OXFORDSHIRE COUNTY COUNCIL'S RESPONSE TO CONSULTATION ON THE FOLLOWING DEVELOPMENT PROPOSAL

Application no: 21/03522/OUT

Proposal: The erection of up to 540 dwellings (Class C3), up to 9,000sqm GEA of elderly/extra care residential floorspace (Class C2), a Community Home Work Hub (up to 200sqm)(Class E), alongside the creation of two locally equipped areas for play, one NEAP, up to 1.8 hectares of playing pitches and amenity space for the William Fletcher Primary School, two vehicular access points, green infrastructure, areas of public open space, two community woodland areas, a local nature reserve, footpaths, tree planting, restoration of historic hedgerow, and associated works

Response Date: 22 February 2023

FIGURE 71 - OPTION 1) AT-GRADE RAISED TABLE CROSSING OVER YARNTON RESIDENTIAL AND NURSING HOME ACCESS ROAD

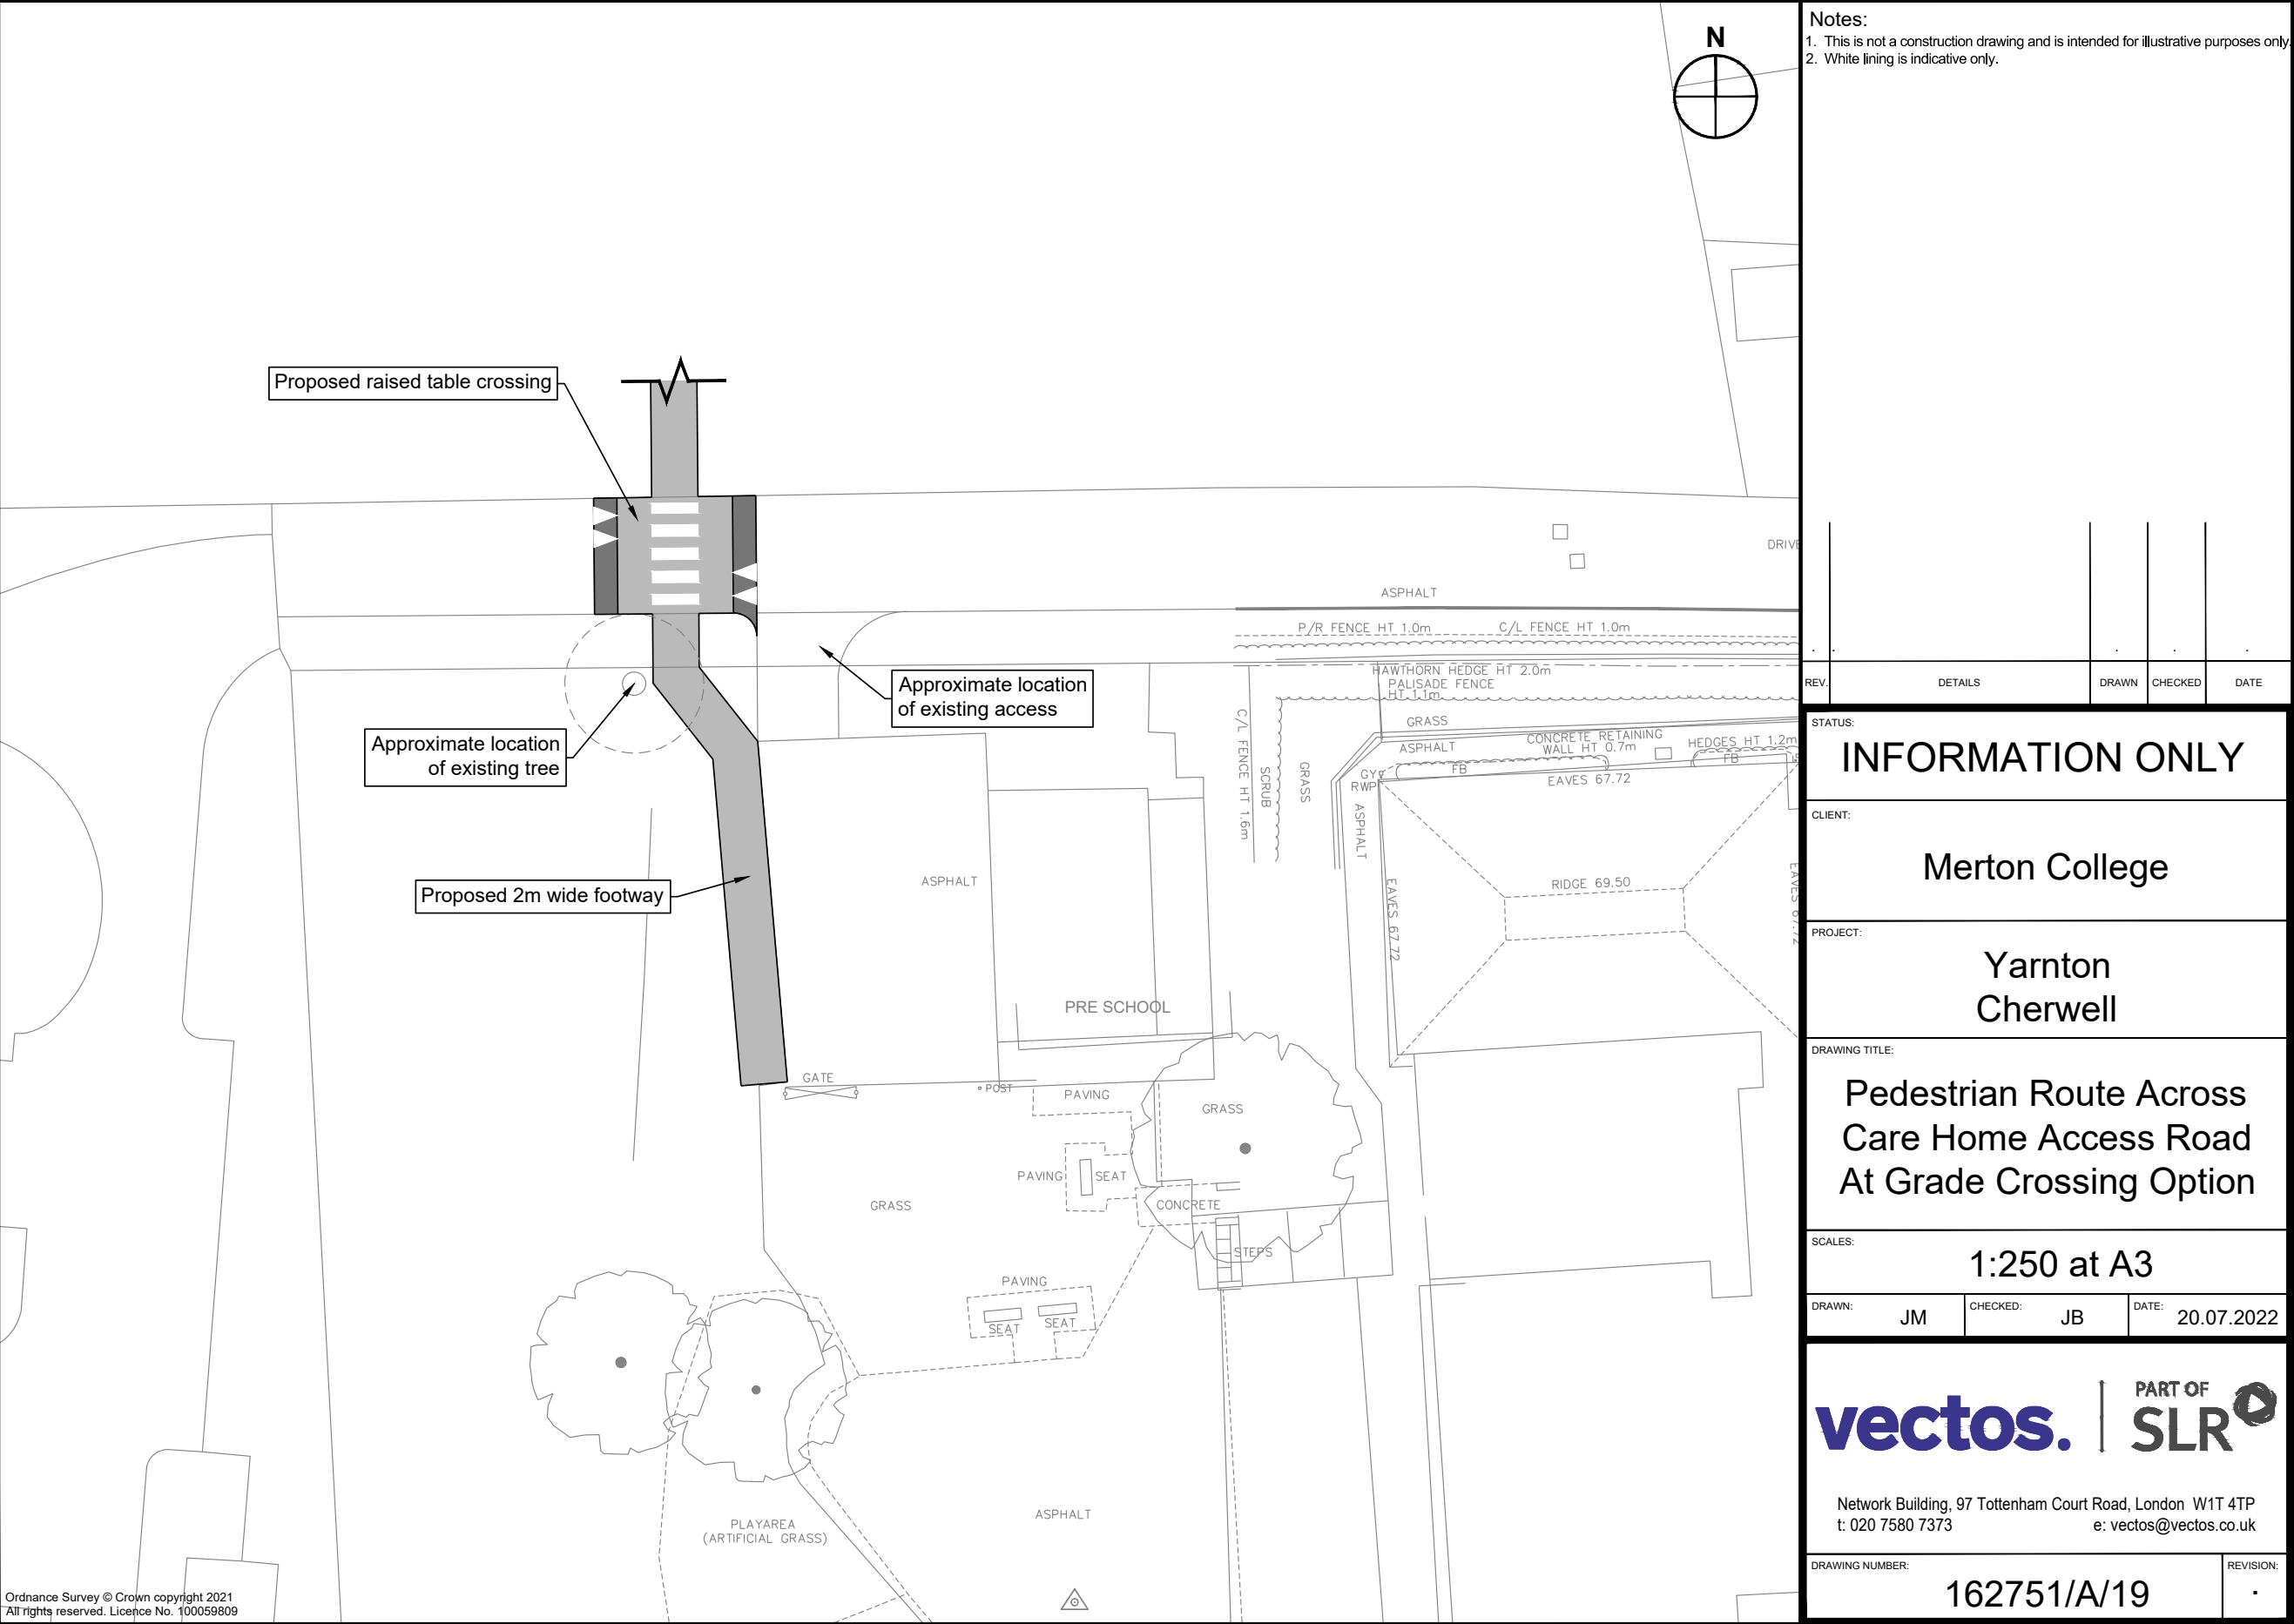
A number of discussions have taken place between OCC, Sanctuary Care Home and the PR9 site developers regarding access to the land reserved for the expansion of William Fletcher Primary School and the use of the existing access road to Sanctuary Care Home, which bisects the school expansion land from the exiting school site. The

latest position, which is reflected in the revised plans, is that Sanctuary would continue to take access from the existing care home access road but that crossing facilities would be implemented over that access road. Vehicle access for school staff car parking would also be taken via the existing access road. Under this arrangement, access to the expansion land would need to be staffed and managed by William Fletcher School. While this is not ideal as it would have resource implications for the school it is not unprecedented. Vehicle movements to the care home during the school day are likely to be low and it is not considered that this arrangement, with appropriate management, would lead to significant highway safety concerns. Therefore, I do not object to the proposed access arrangement to the school expansion land and Sanctuary Care Home.
